From: chris barrow [REDACTED]
Sent: 26 April 2018 11:56
To: Andrew Wood
Subject: Re: BR/72/18/CLP - 21 Westloats Lane - confirmation of materials

BR/72/18/CLP - 21 Westloats Lane - confirmation of materials

Sheet No. 4

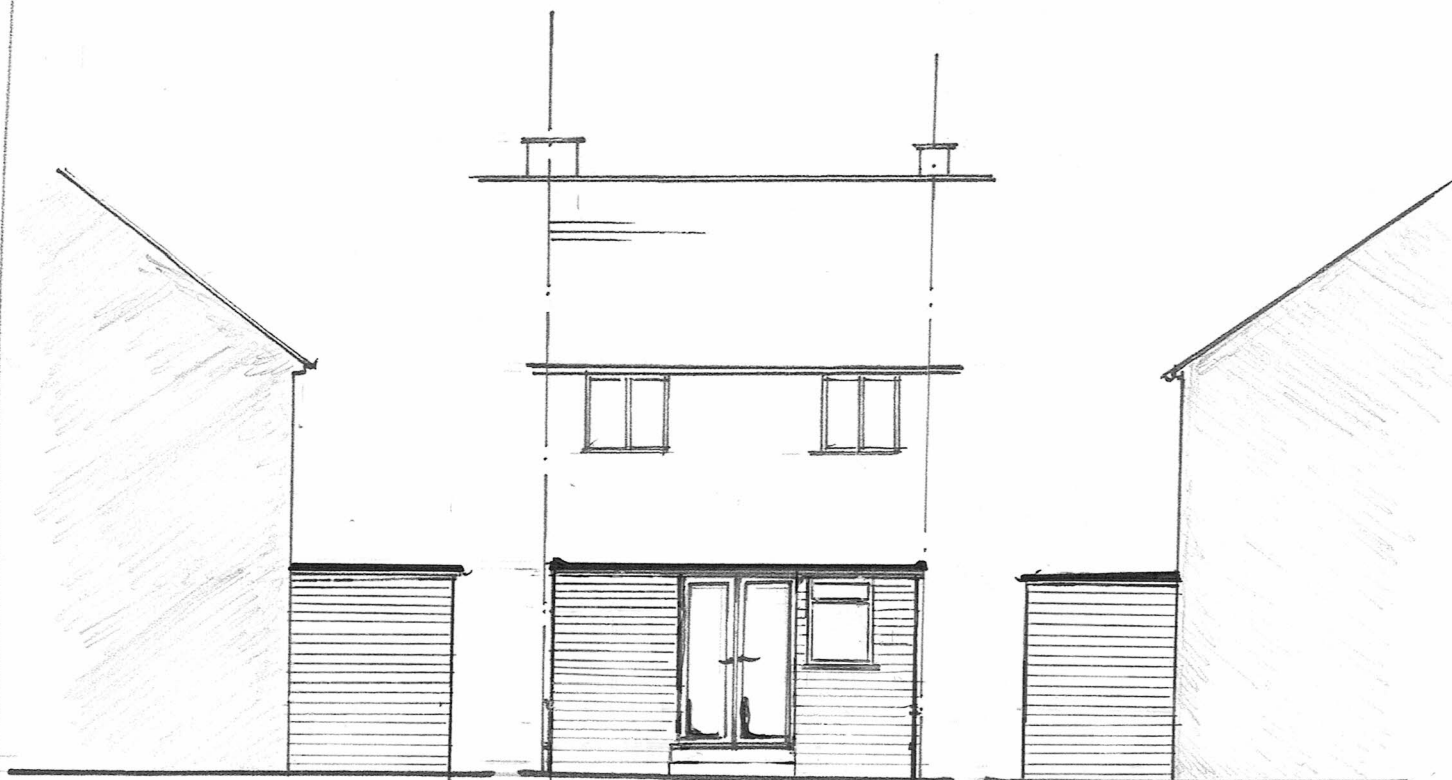
Can you please confirm that the facing brick of the proposed rear extension replacing the conservatory will match the existing brickwork of the main dwelling house at Westloats Lane.

I confirm these bricks will be to match existing.
